Engineers Comments Regarding Condition 4- surface water drainage

APPLICATION BE/60/19/DOC

Registered: 10-MAY-19
Site Address: 182 Chichester Road Bersted PO21 5BJ
Description of Works: Approval of details reserved by condition imposed under ref BE/66/16/PL relating to Condition Nos 3 - schedule of materials & finishes, 4 - surface water drainage, 5 - landscaping, 6 - screen fences and 7 - secure storage of bicycles.

Client
Simon Abbot
Drawing Title
Surface Water Drainage

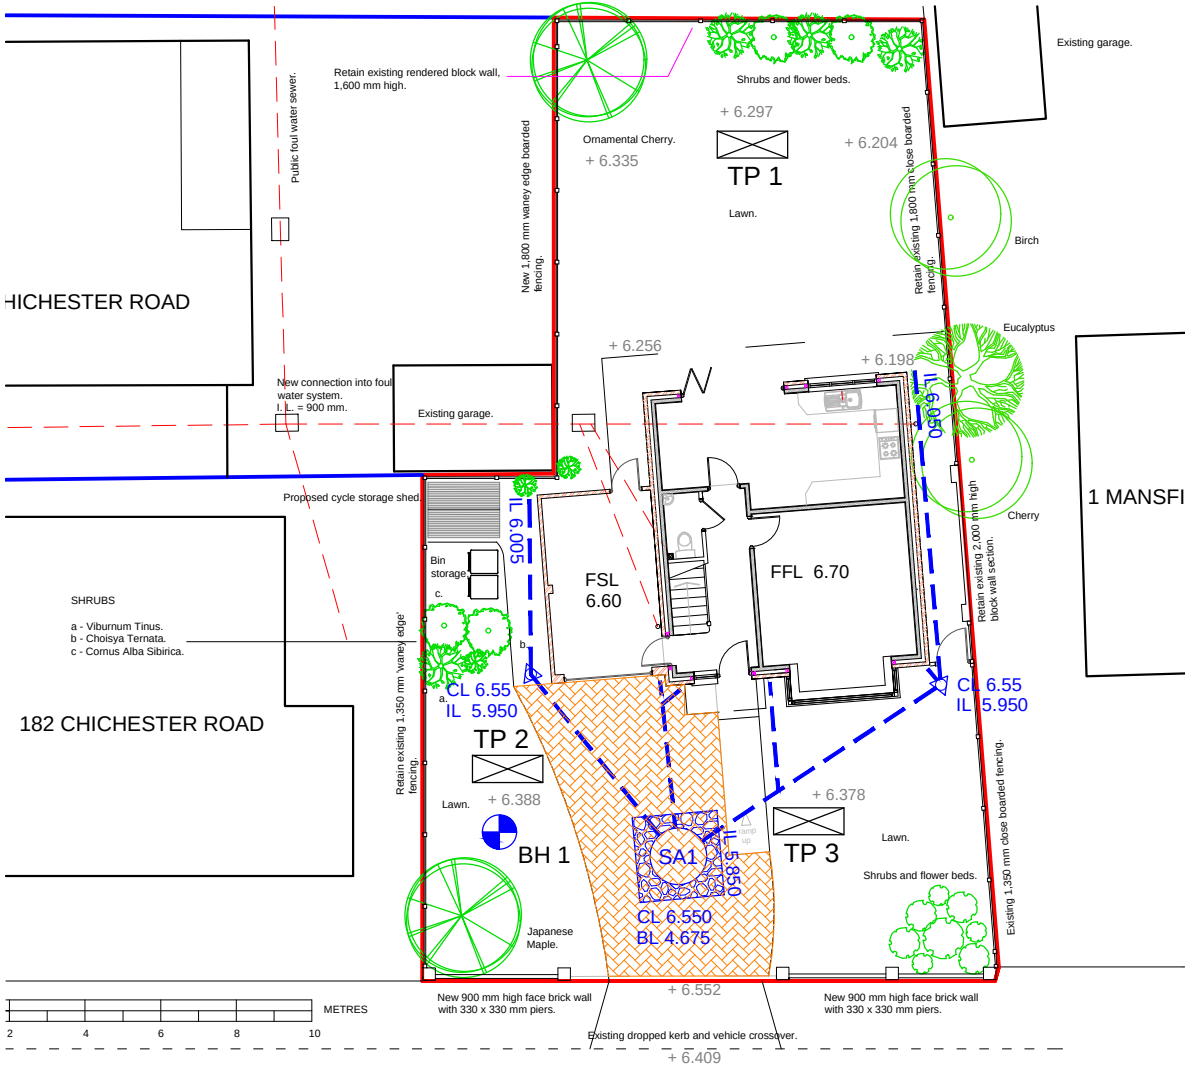
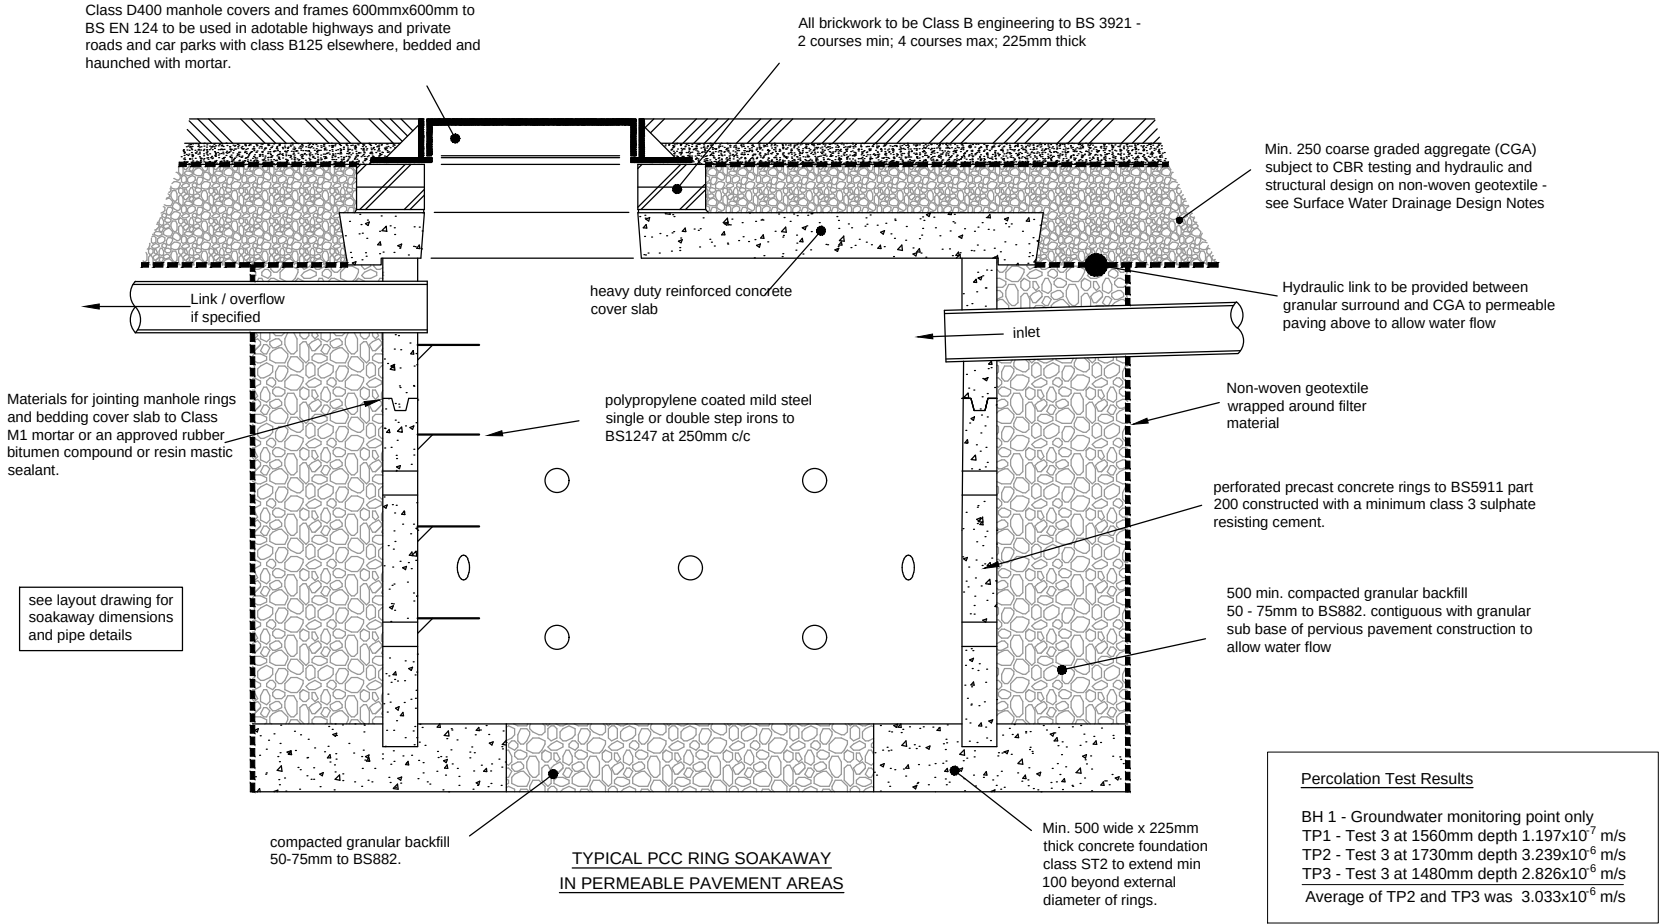
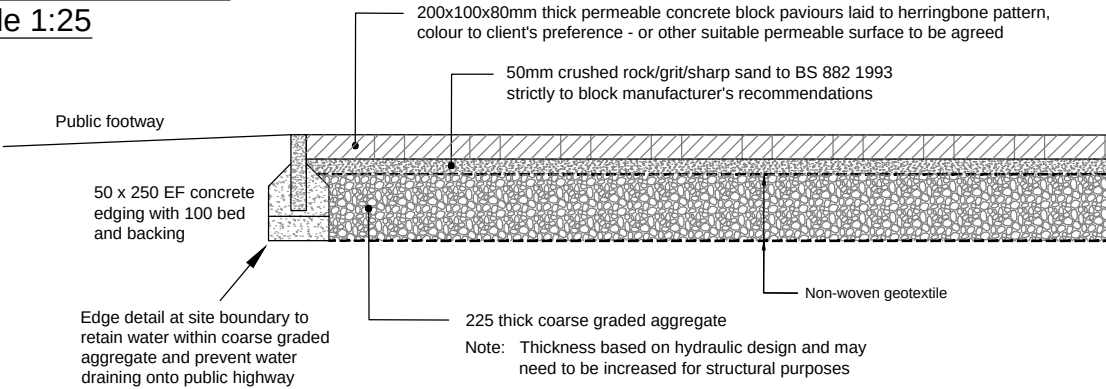
- No calculations have been submitted with the application. Please can these be provided.
- Average infiltration rates have been used in design. We require worst case results to be used. Please can further detail on the infiltration testing results be submitted, i.e. depths and locations of testing and results.
- It is unclear if winter groundwater monitoring has been completed. Please can the applicant confirm the duration of groundwater monitoring.
